Project No.: The Tanglewood-Mirror
DATE: JUNE 15, 2020
DRAWN BY: Steven Madden
DESIGNED BY: Steven Madden
REVISED:

Sheet Title
FRONT & REAR ELEVATIONS

BUILDER	Camberland Homes, Inc.	CITY / CO	Johnston Co. / Johnston
JOB NAME	Holland Residence	ADDRESS	Site Address
PLAN	Holland Residence	MODEL	Roof
SEAL DATE	Seal Date	DATE REV.	03/01/22
QUOTE #	J0225-1061	DRAWN BY	David Landry
JOB #		SALES REP	Larry Norris

BONUS ROOM FLOOR PLAN
SCALE: 1/4" = 1'-0"

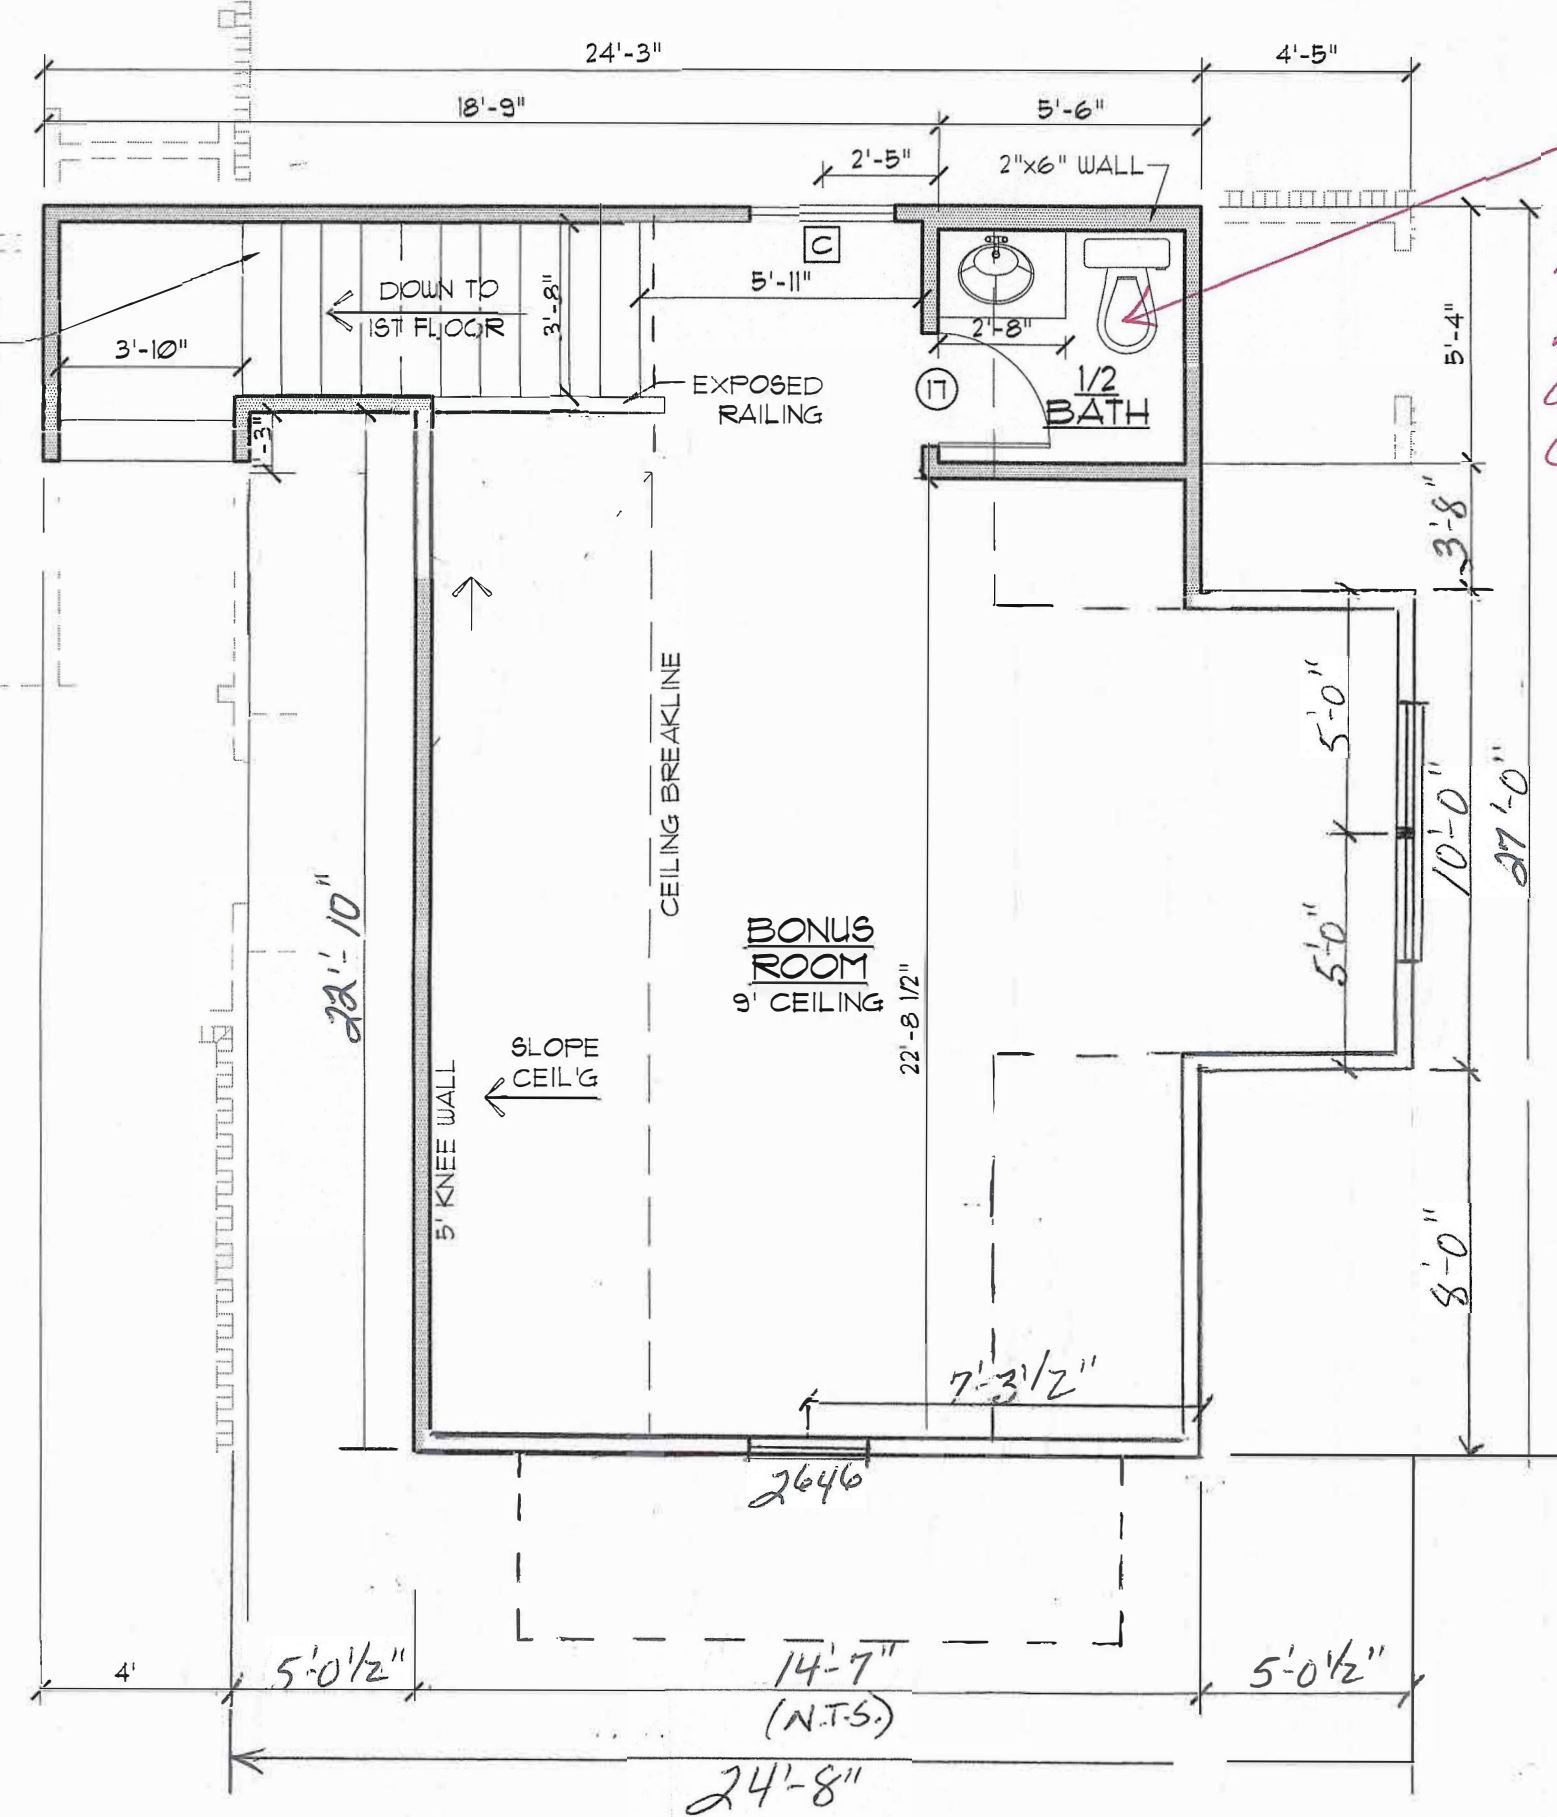
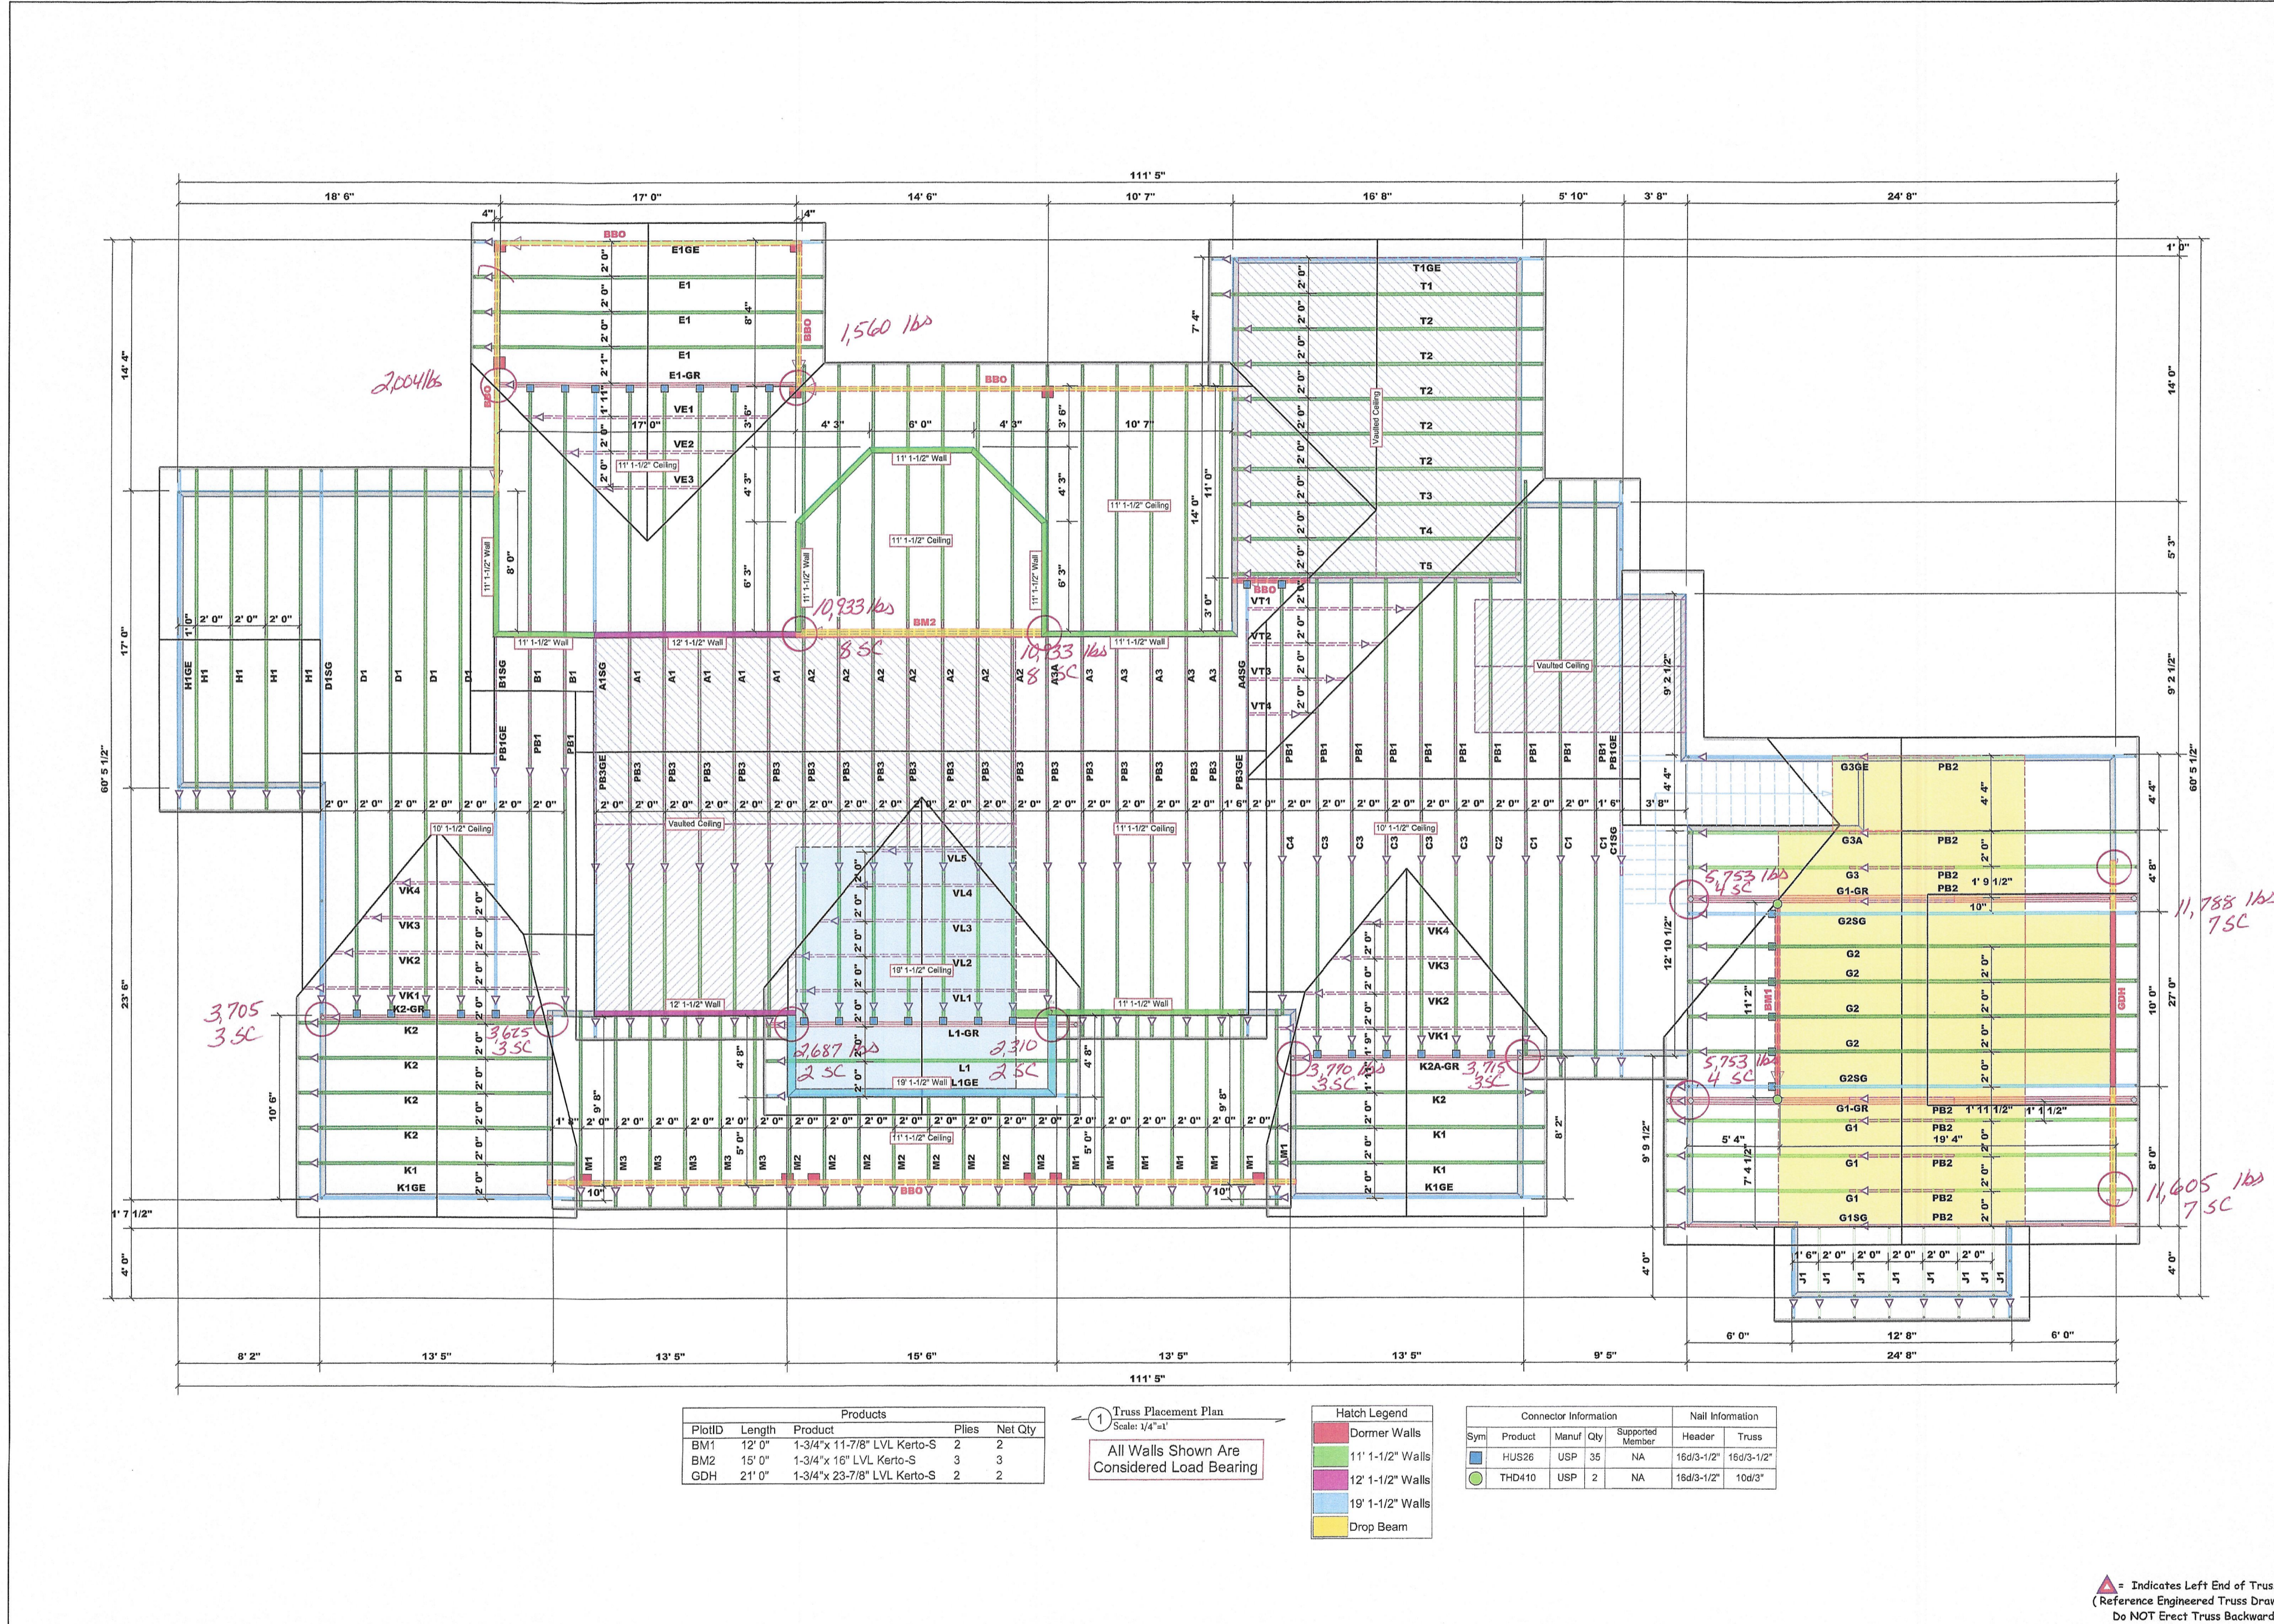
Steel height will need to be raised to achieve 6'-8" Clear Headroom @ E of Toilet.

FOUNDATION PLAN
 SCALE: 1/4" = 1'-0"

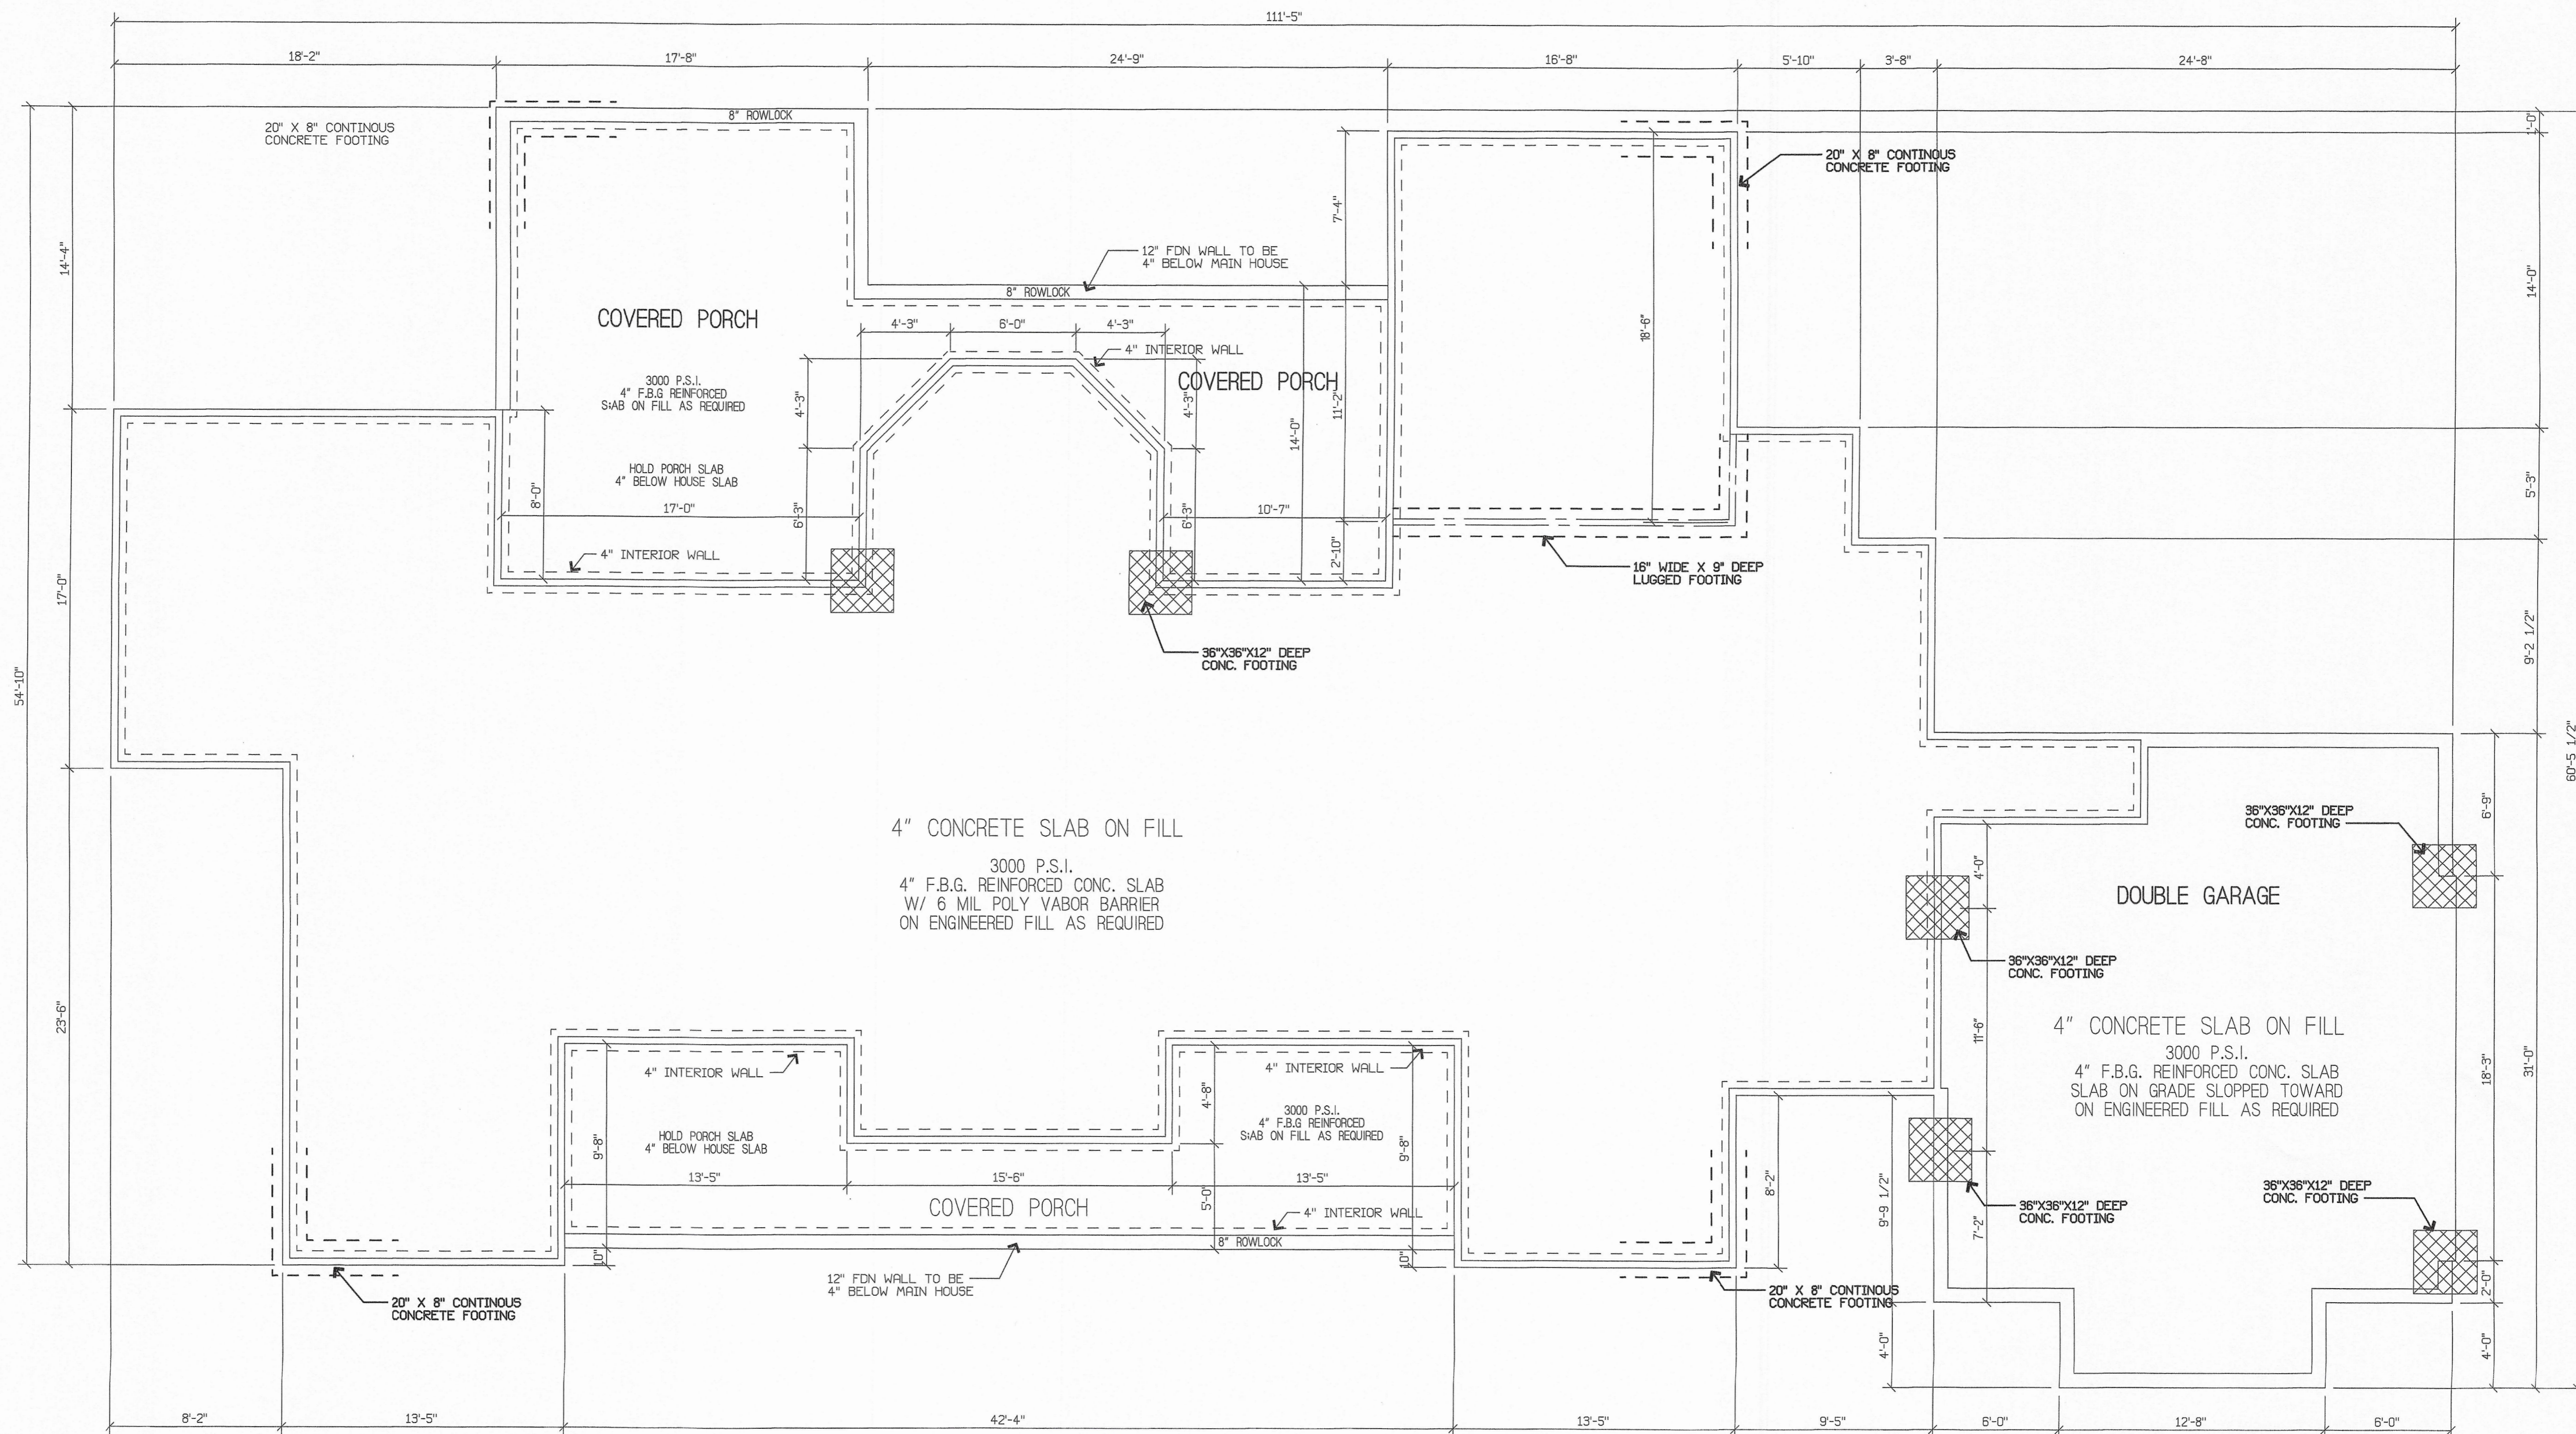
Brady
 This is the worst foundation
 Plan I have ever seen. Therefore
 I drew a new one from scratch
 to meet local standards & dimension
 accurately without the brick ledge.
 Thanks, *Jeff Davis*
